TfL Post Stage 1 Comments:

Broadwater Lake

Stage 1 Comment: (11 th Dec 2023)	Revised scheme comment: (11 th March 2026)
Access	
Access to the site is via a private access road off Moorhall Road. There are currently no footways or street lighting present on the access road. Improvements to this site access road and junction, which includes the provision of a dedicated pedestrian footway, new street lighting and introduction of a 20mph speed limit are proposed. These improvements have been subject to a Stage 1 Road Safety Audit, the findings of which should be considered with the relevant highway authority.	As the highway authority the RSA should be agreed by Hillingdon. Access improvements have been highlighted including new street lighting. Confirmation of where this is to be located and how this is to be secured is required.
It should be ensured that the proposed access is designed in line with the Mayor's Healthy Streets approach, with priority given to modes of sustainable and active travel over that of private vehicle. On the General Arrangement Plans there are several stretches of access road where the footpath changes sides without any crossing or demarcation. This should b

DO NOT SCALE OFF THIS DRAWING

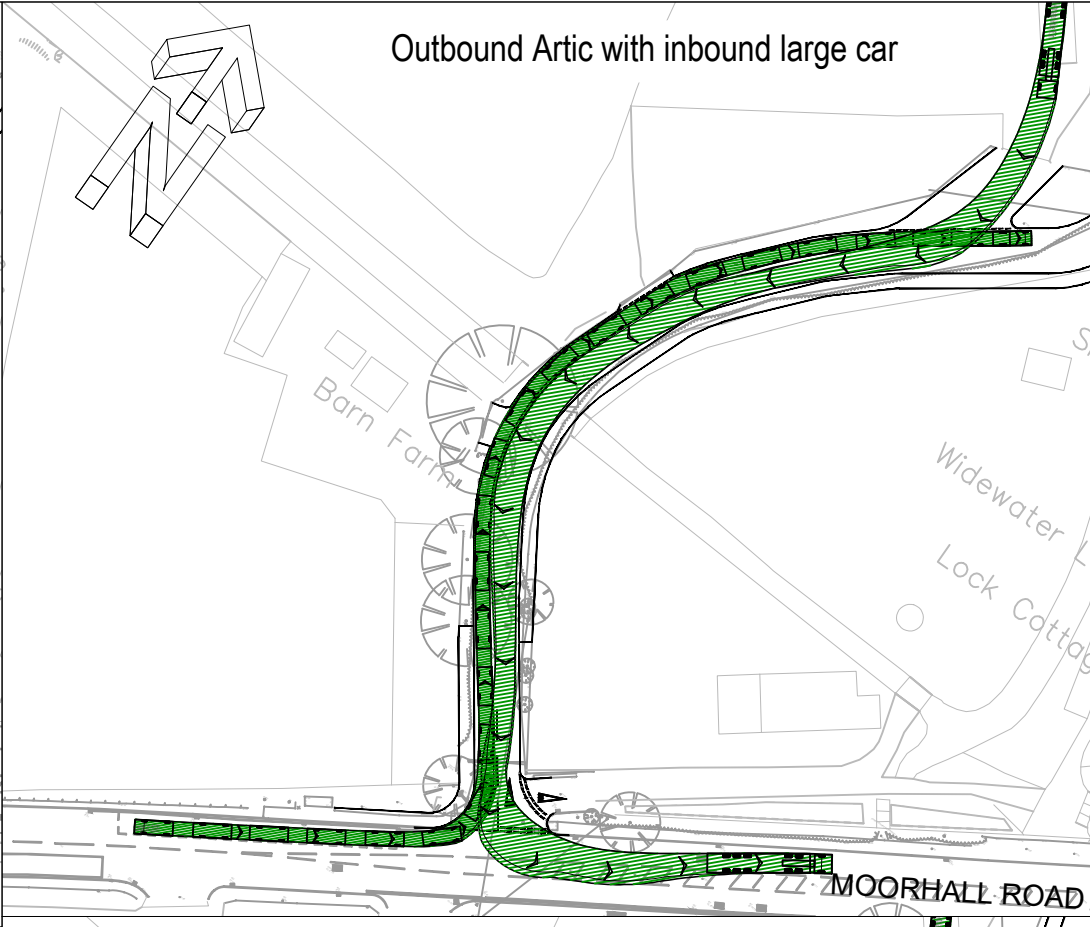
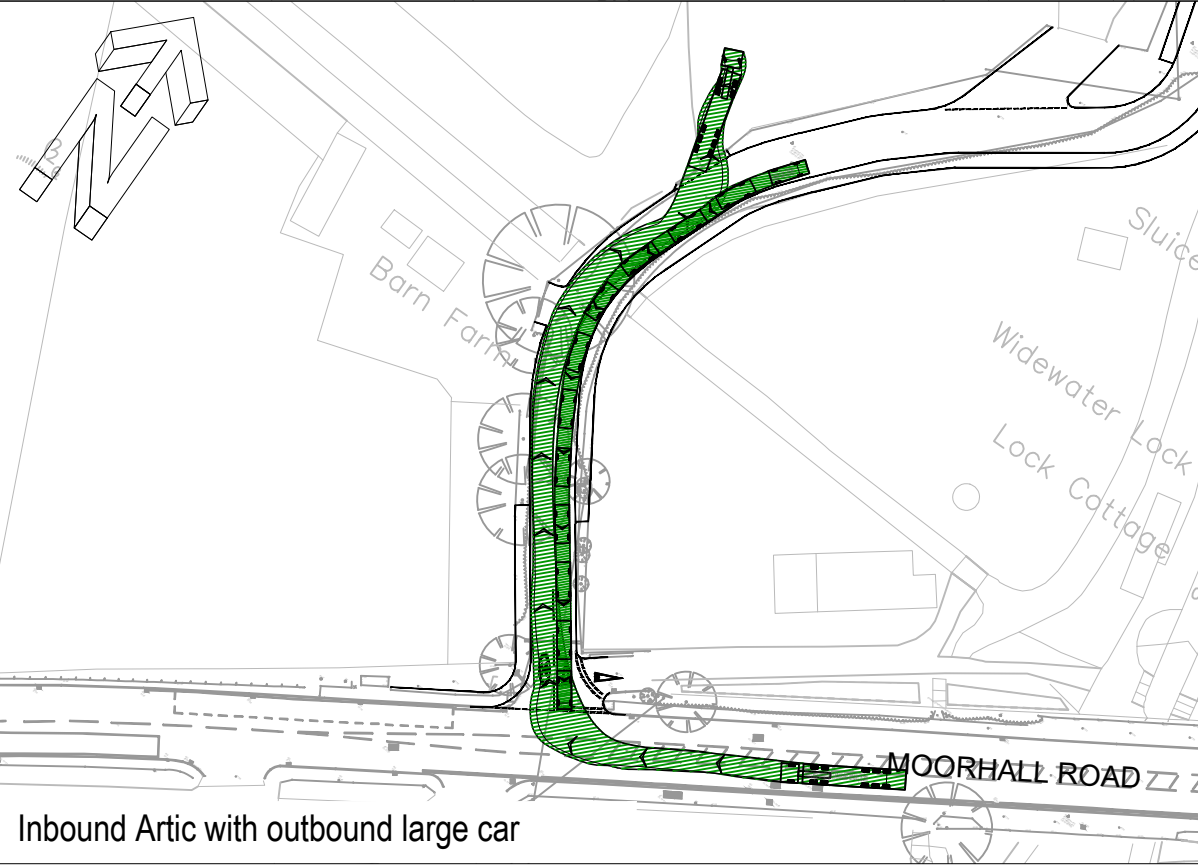
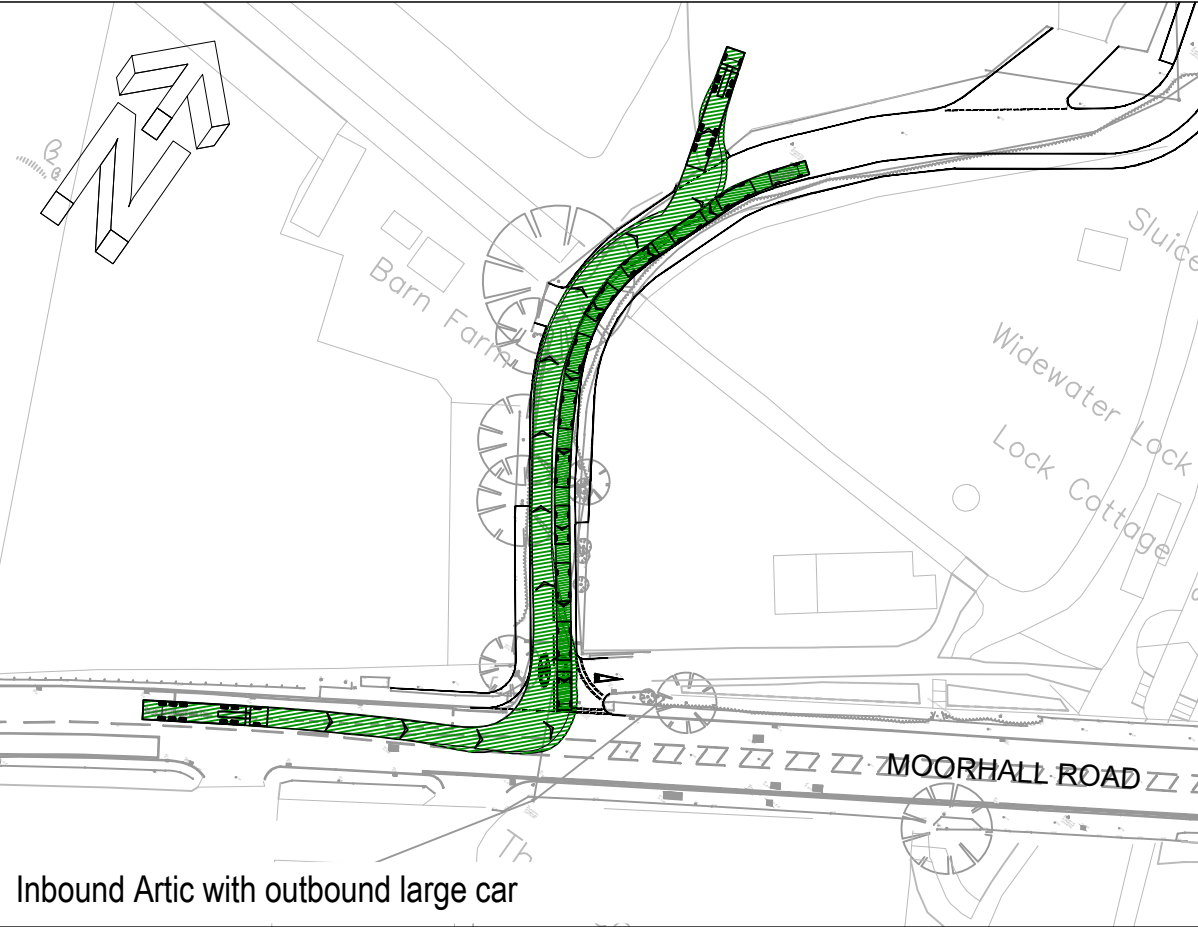
pedestrians. Additionally, the proposed footpath and pedestrian crossings need to be shown more clearly on the swept path analysis. Further information on signage and wayfinding, within the site and on adjoining streets and the canal are required to be delivered.	
Car Parking	
A total of 83 vehicle parking spaces are proposed across the site. As noted in Policy T6.4, parking for leisure uses should be assessed on a 'case-by case basis, ensuring that it is consistent with the Healthy Streets Approach, mode share and active travel targets, and the aim to improve public transport reliability and reduce congestion and traffic levels.' No clarity has been provided on how the figure of 83 was arrived at. Furthermore, when noting the information on number of peak users over a day, there is a concern that 83 parking spaces is a significant overprovision	<i>'A total of 42 vehicular parking spaces are provided'</i> , plus drop off facilities. This represents a reduction of 41 spaces from the previous scheme, which TfL welcomes. However, further information on how the car parking figure has been arrived at is required in order to ensure the proposals meet all relevant London Plan policy and robustly demonstrates case by case parking policy. TfL also query the ability for informal parking on the access roads. Appropriate design and management measures should be implemented to ensure there is no overspill parking.
